**NELSON GEOTECHNICAL  
ASSOCIATES, INC.**

Geotechnical Plan Review Letter  
**Hu Residence Development**  
**30XX – 69<sup>th</sup> Avenue SE**  
**Mercer Island, Washington**  
NGA File No. 11448B20

SHEET:  
**A3.01**

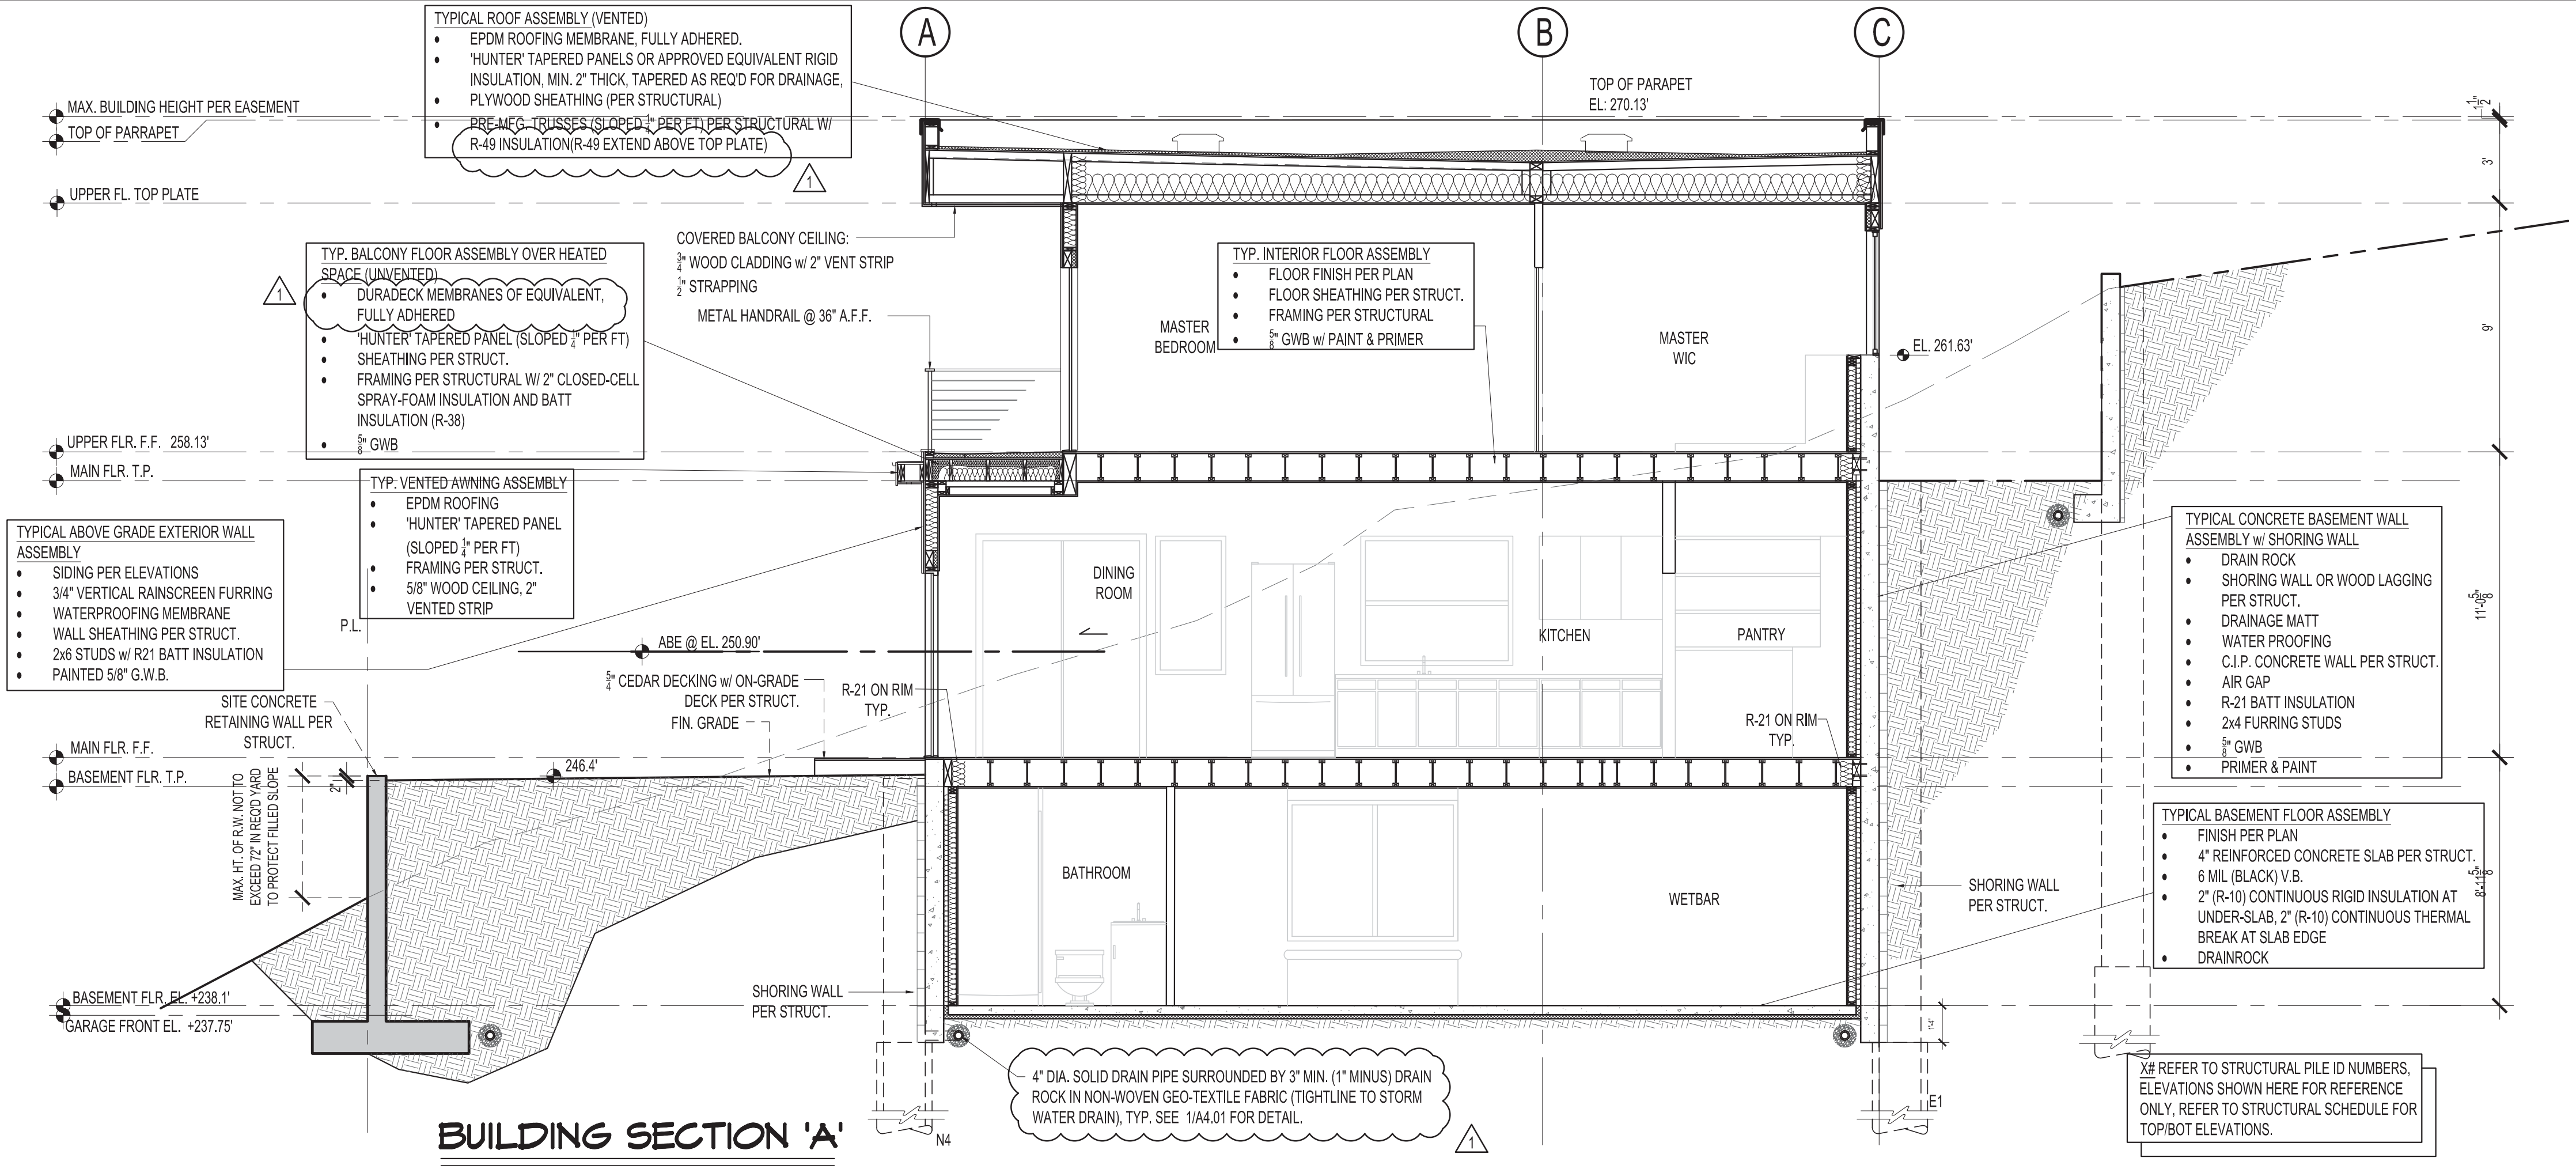
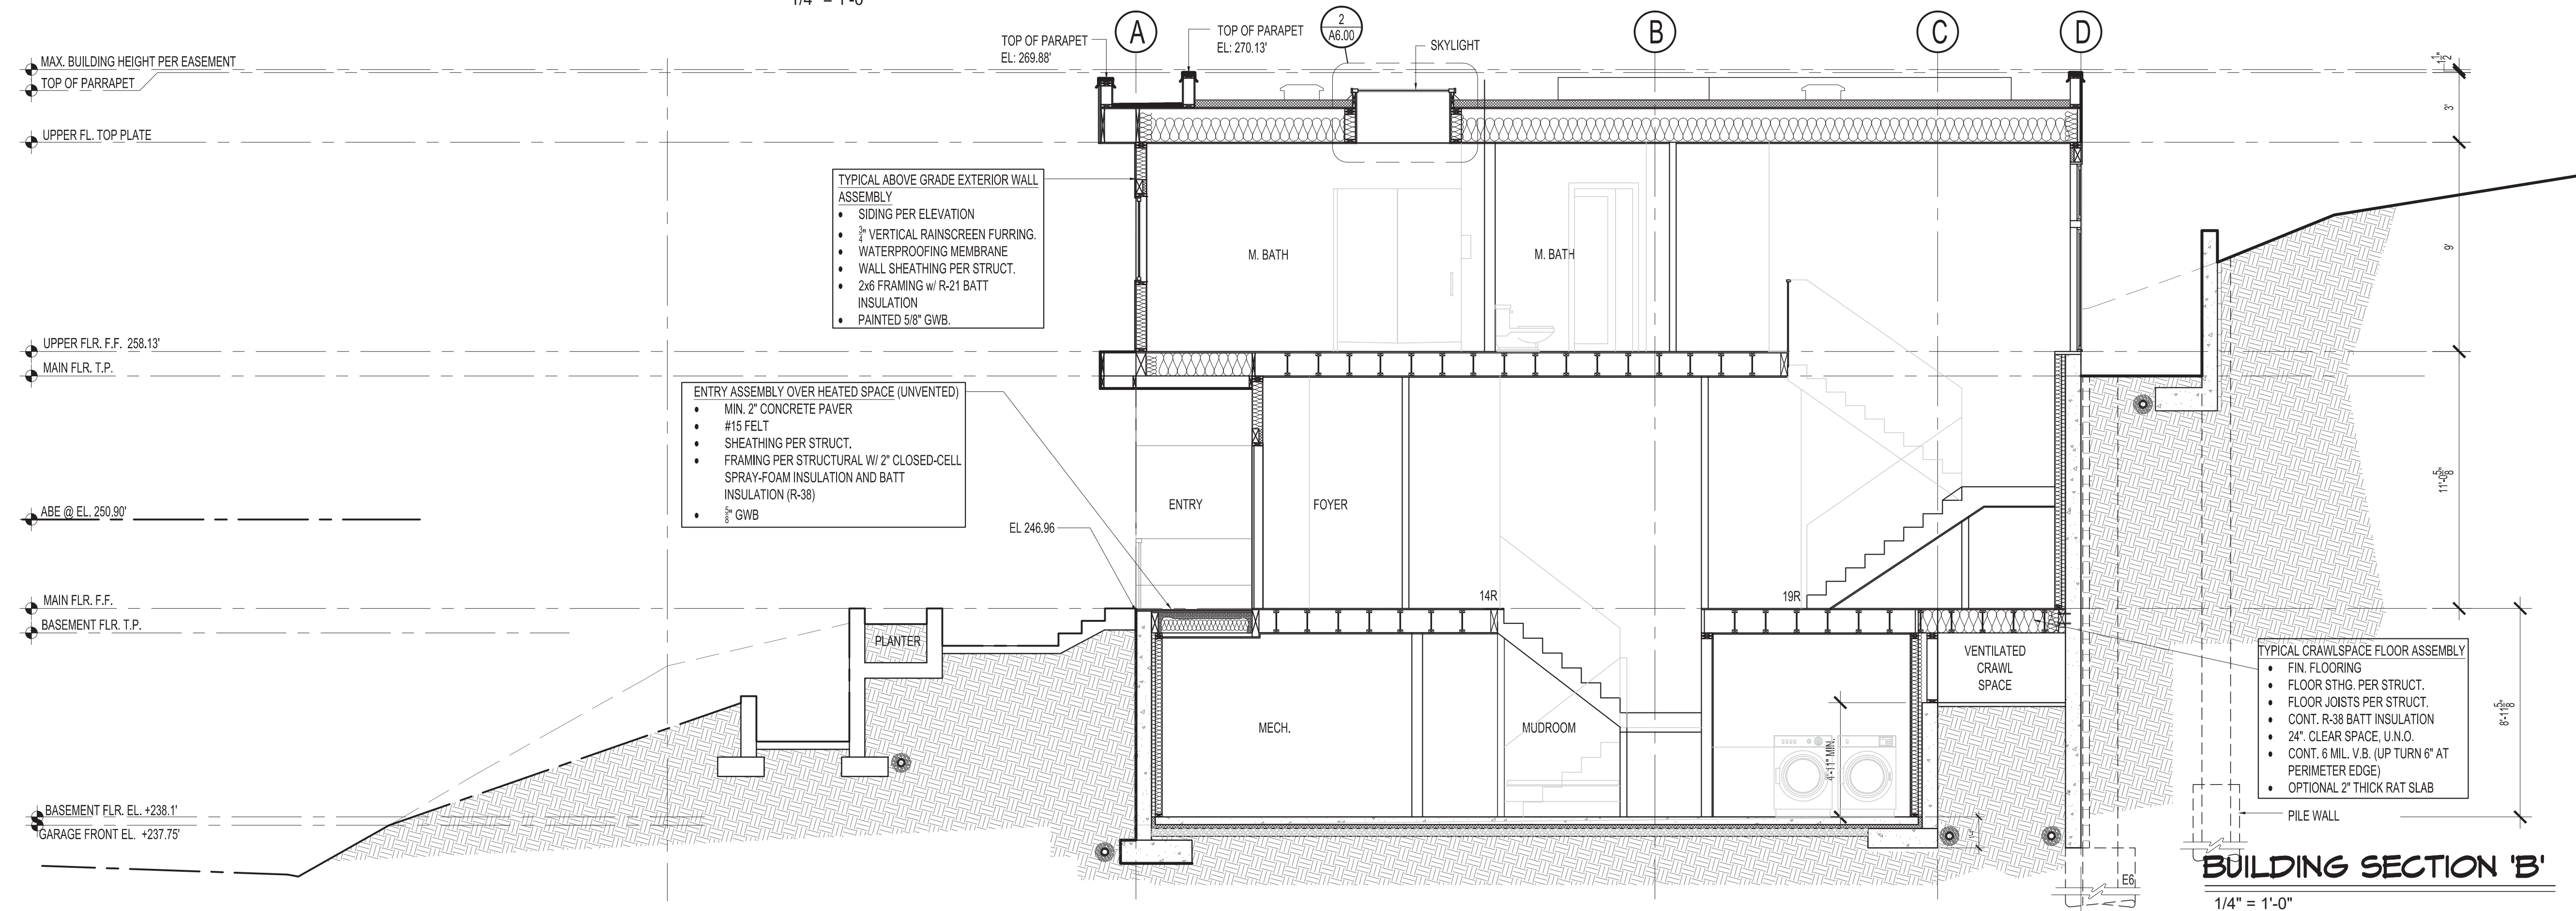
A City review comment on **Sheet A-3.01** concerns a retaining wall that will be constructed close to the residence basement and expresses concern that the retaining wall would surcharge the basement wall unless the upper wall is attached to permanent shoring. The retaining wall in question will be attached to permanent shoring and thus will not surcharge the basement wall.

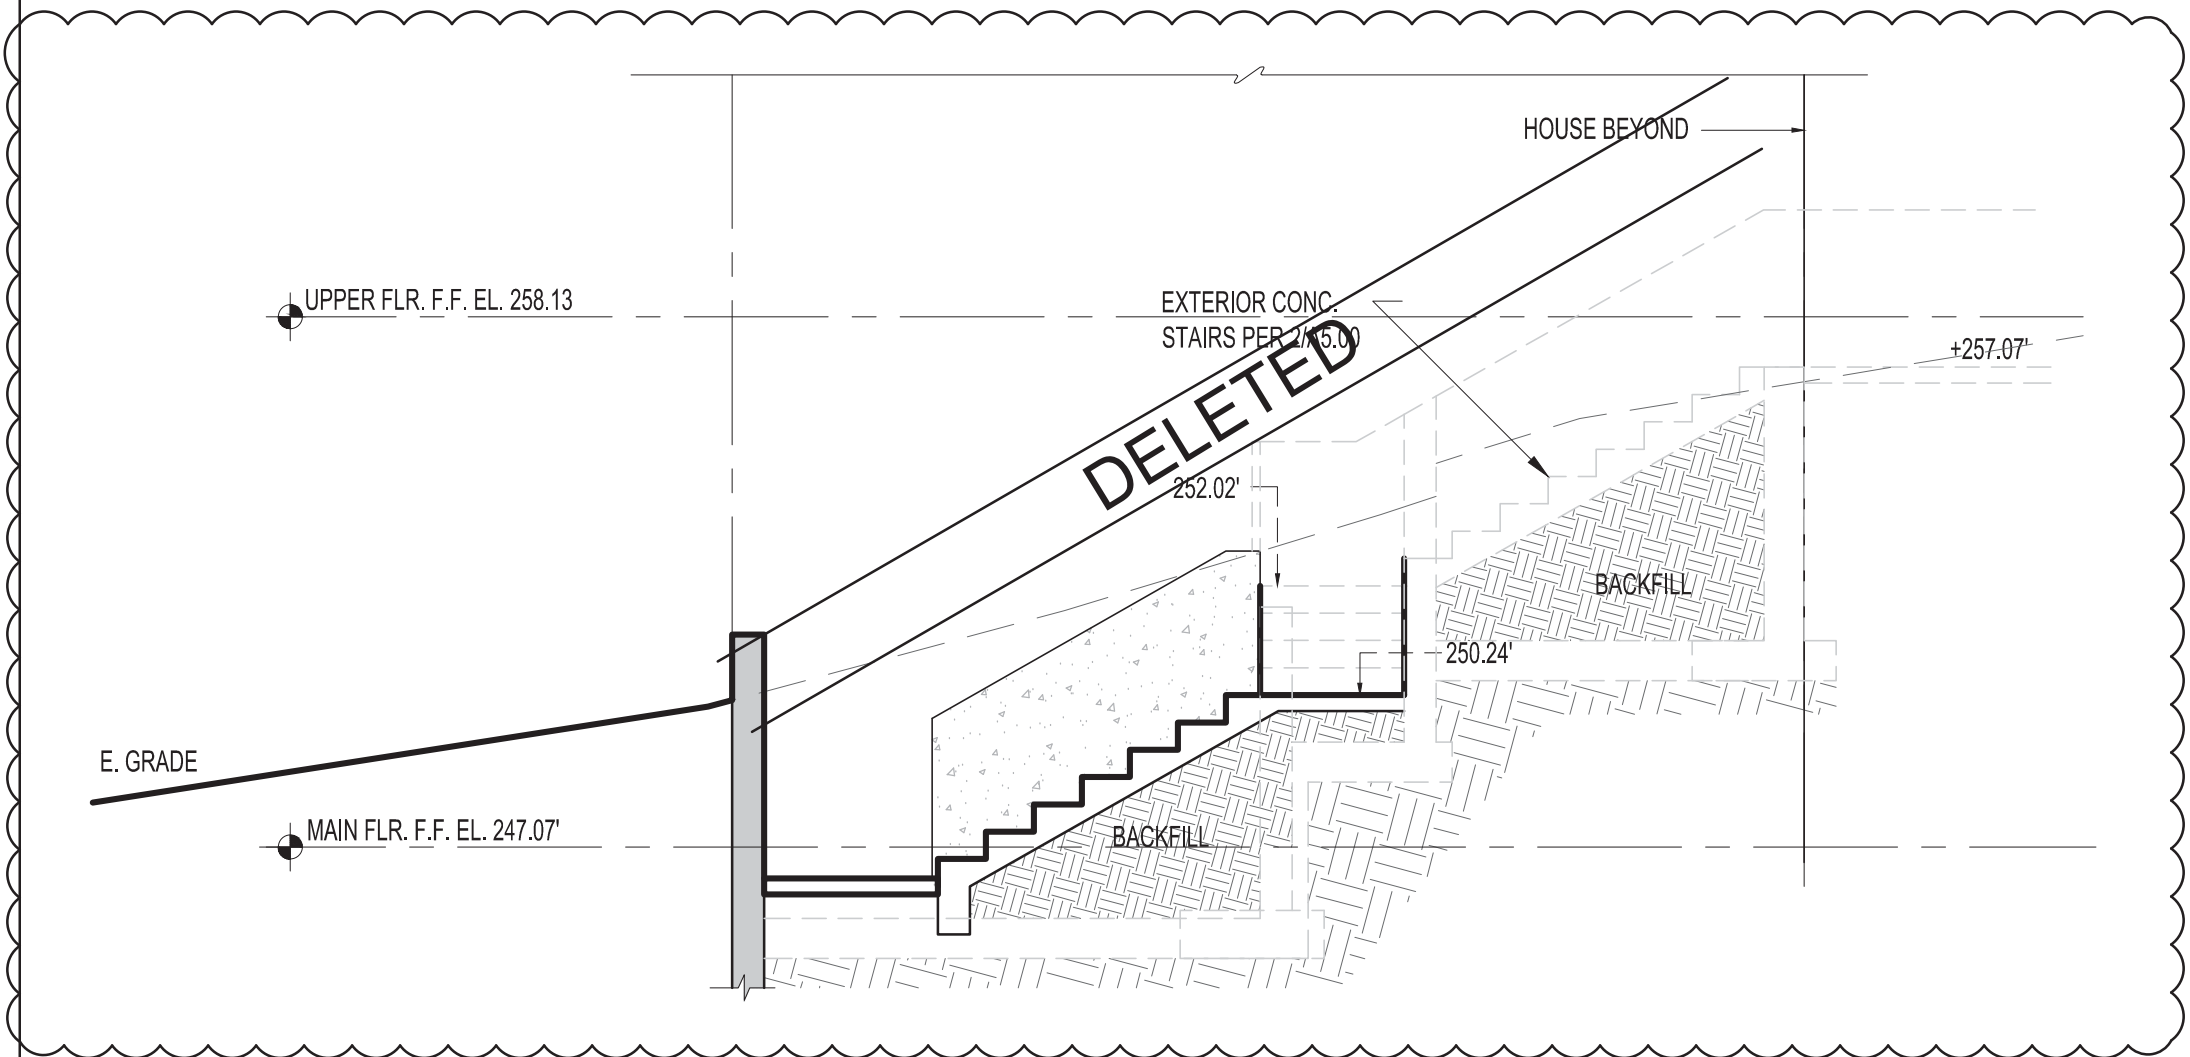
A City review comment on **Sheet A-4.01** concerns drainage recommendations for permanent shoring walls and requests the geotechnical engineer to provide those recommendations. Drainage composite should be placed against the full height of the shoring lagging and should be hydraulically connected to weep holes that extend through the base of the permanent wall facing. Those weep holes should be spaced 8 feet on center and should be tightlined to the stormwater system. The shoring wall drainage recommendations are illustrated in Figure 10 which is attached to this letter. Detail 1 on Sheet **A4.01** incorporates those drainage recommendations into project plans.
